Harnett County
420 McKinney Pkwy
LILLINGTON, NC 27546
Phone:
Fax:

SUBJECT: **SFD2309-0035**
SINGLE FAMILY DWELLING

Here are the results of all Inspections located at **115 ITHICA LN:**

Inspection Type: ROUGH IN
Scheduled Date/Time: 4/7/2025
Completed Date/Time: 4/7/2025
Inspector: James T Hall
Result: DISAPPROVED

CEILING FRAMING PLAN

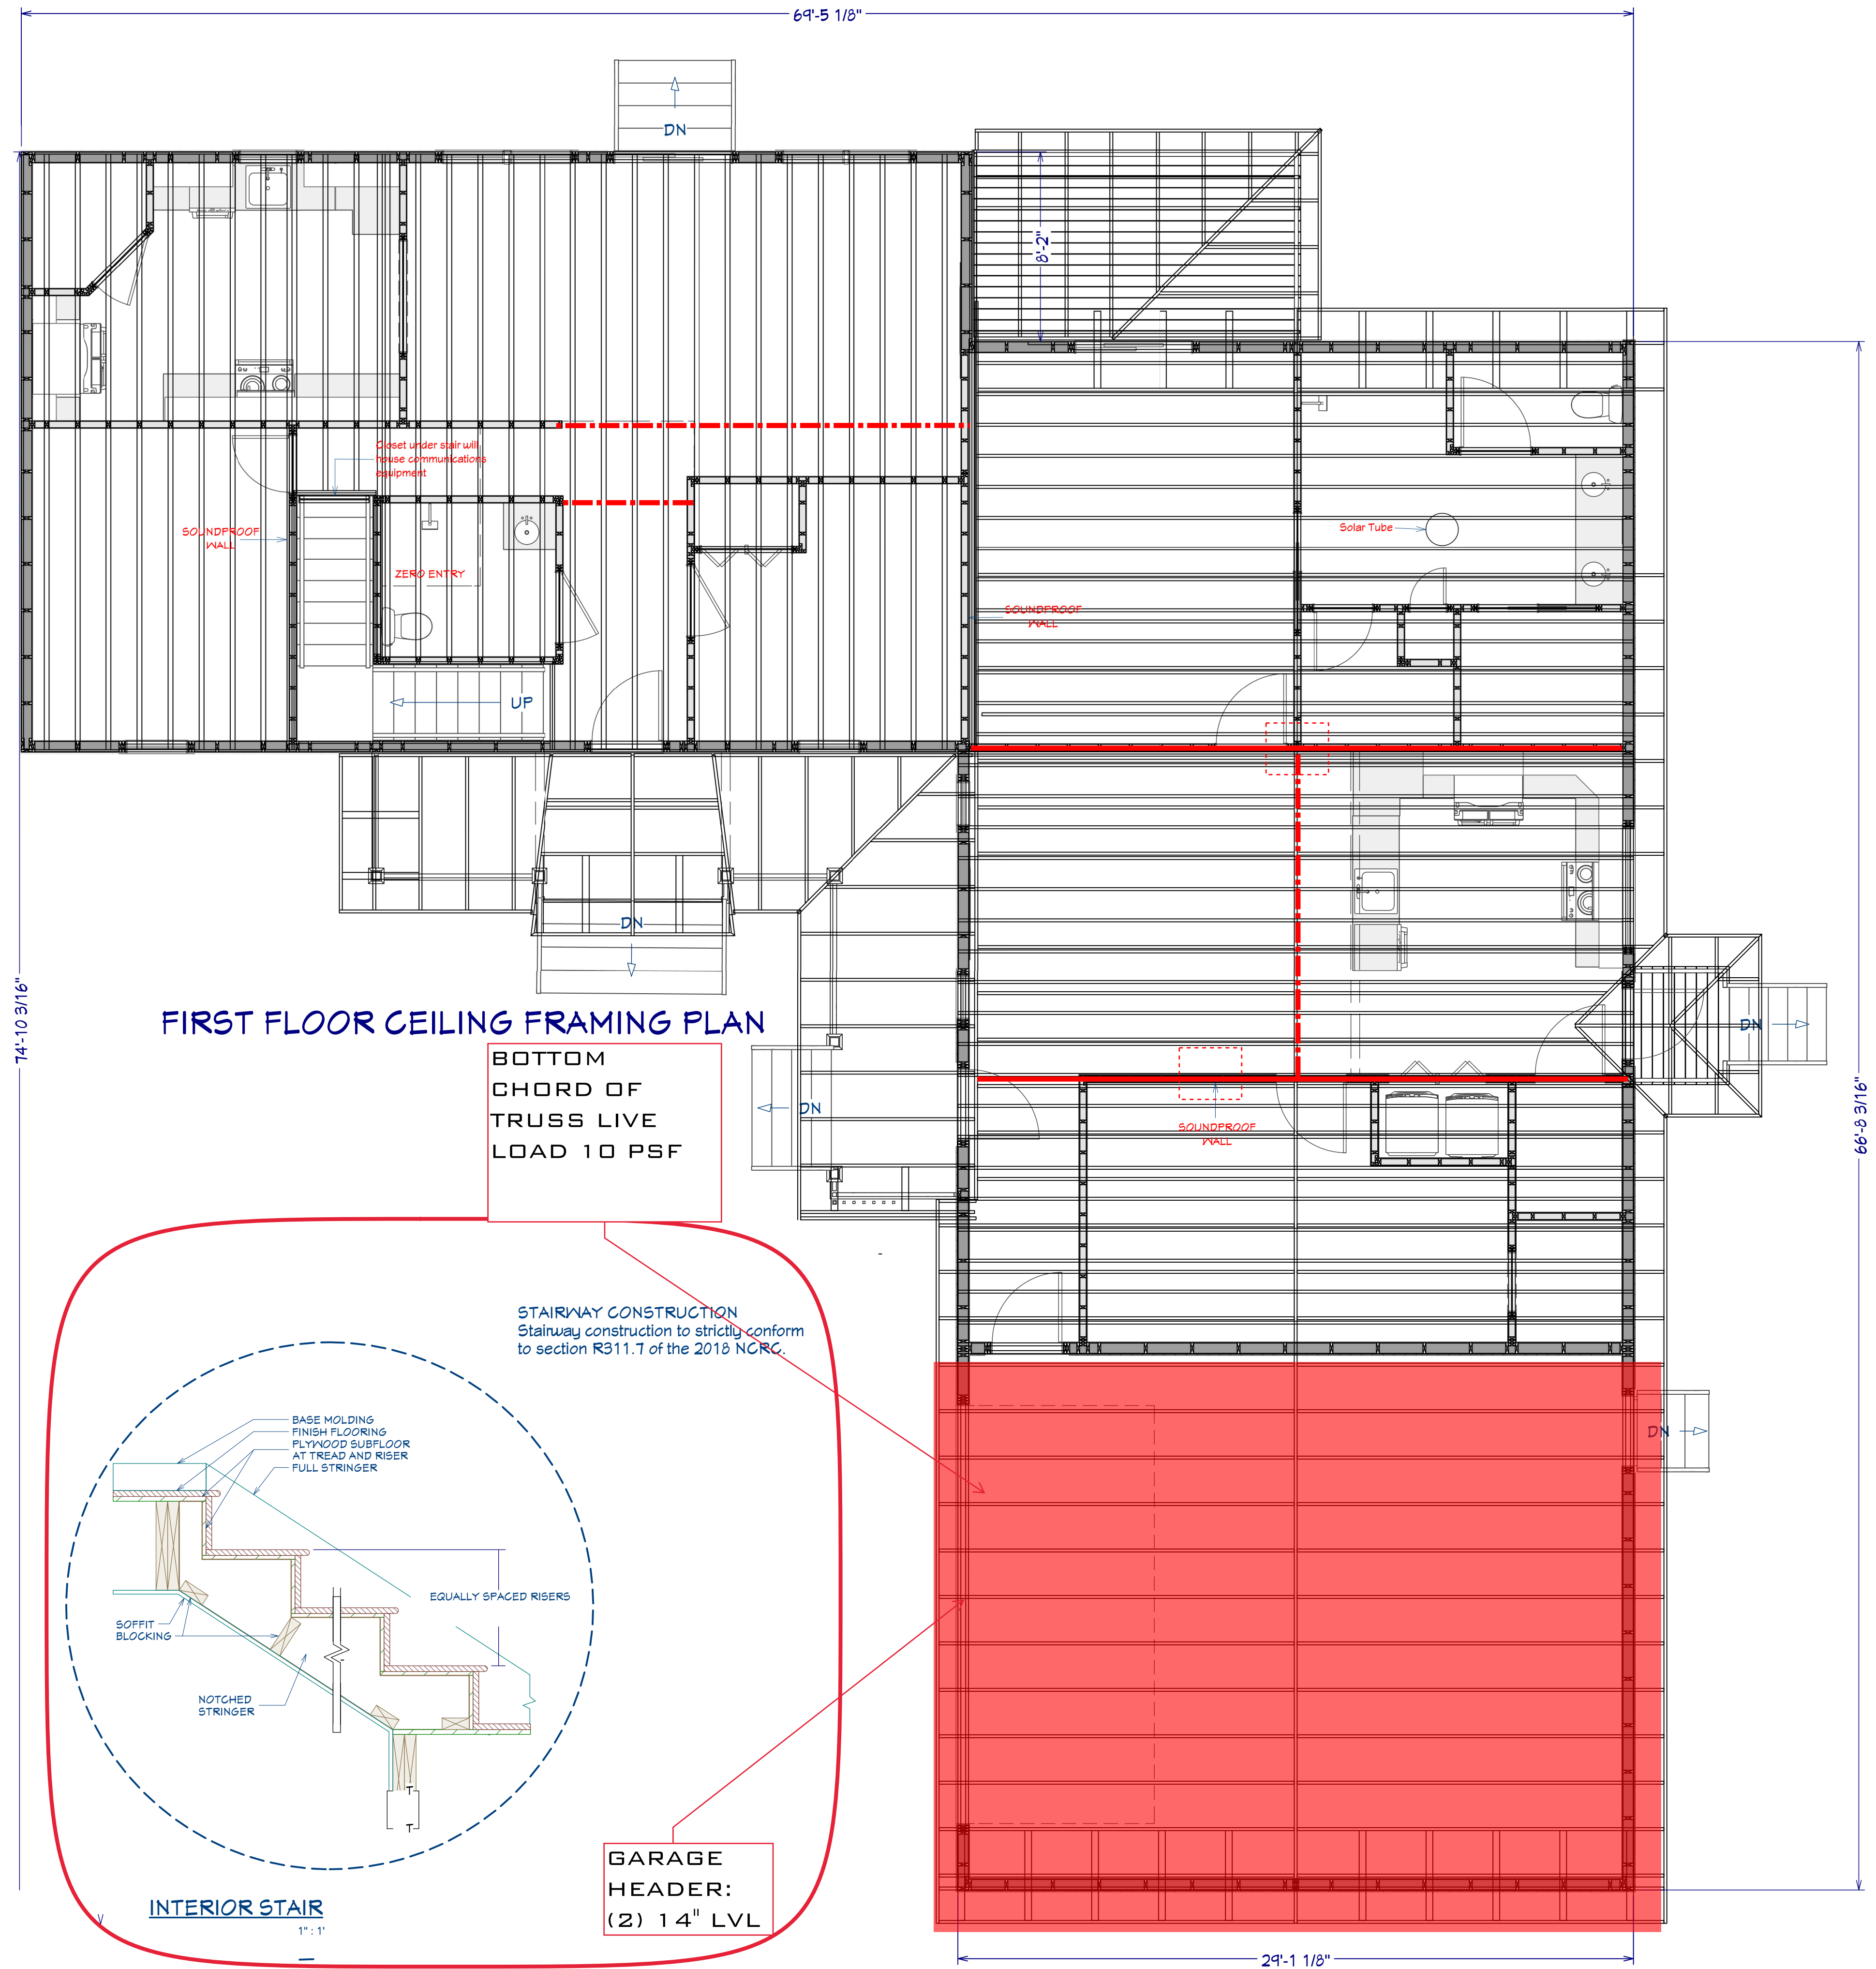
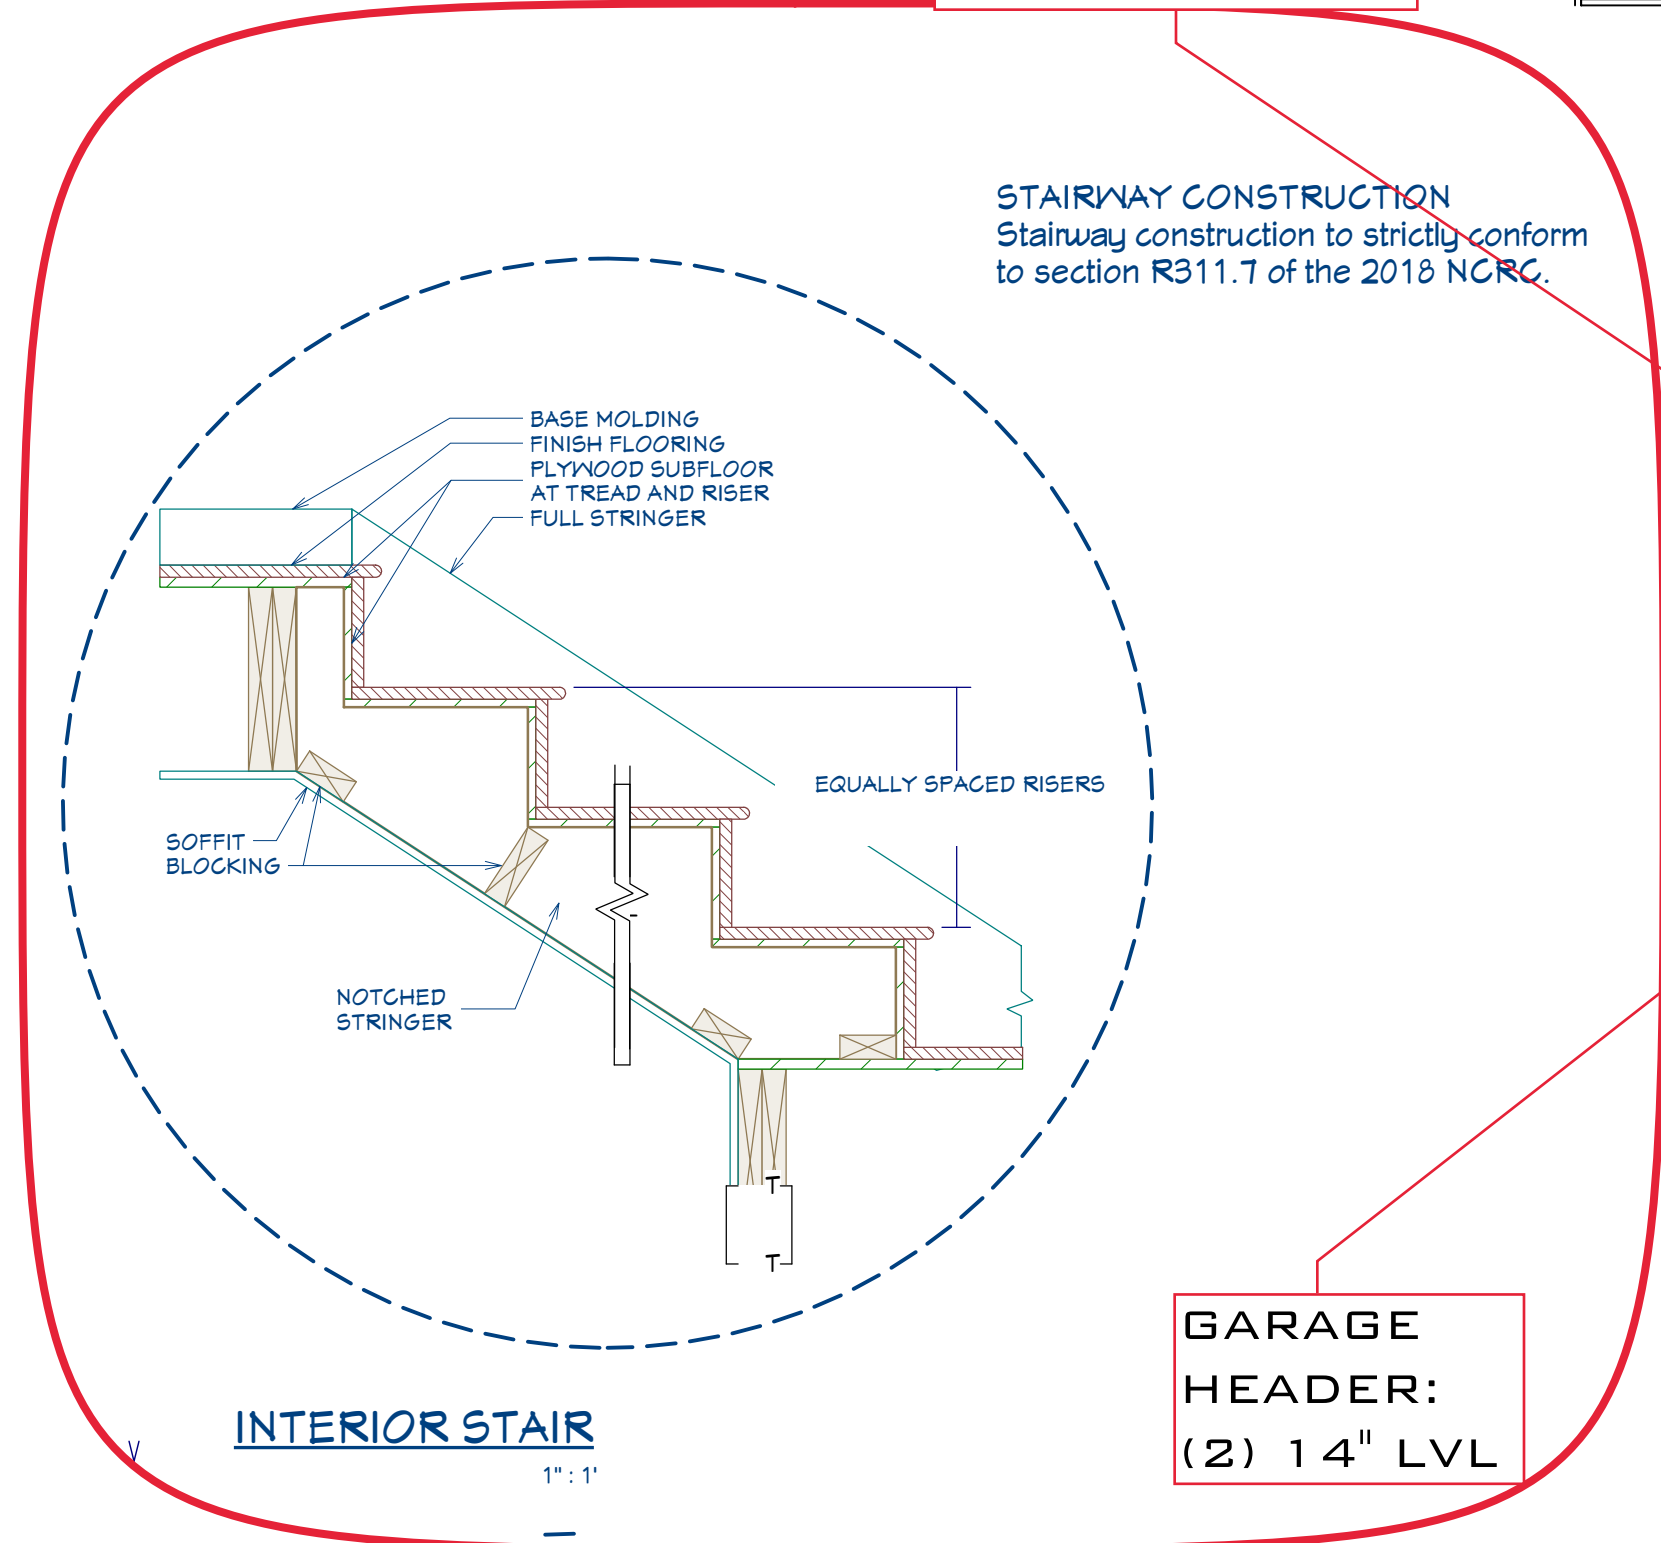
1. House already sided need third party engineers letter on porch beams covered
2. Porch post not installed at time of inspection
3. Nail lvl beam at garage door per documents and need cut sheets for the lvl beams

7. Fire caulk dryer duct at top plate
8. Need correct nail guards on 2" pipe in laundry room
9. Fire caulk hole under dryer box
10. Plans show a lvl beam in kitchen and they have a 3 ply 2x10 beam and need to know the load on the headers where it bares

17. Need letter for damage on 2 ply lvl beam in living room
18. Replace floor joist over back right kitchen door over notched and bored in center 1/3
19. Missing nail guard on water lines in kitchen on left wall
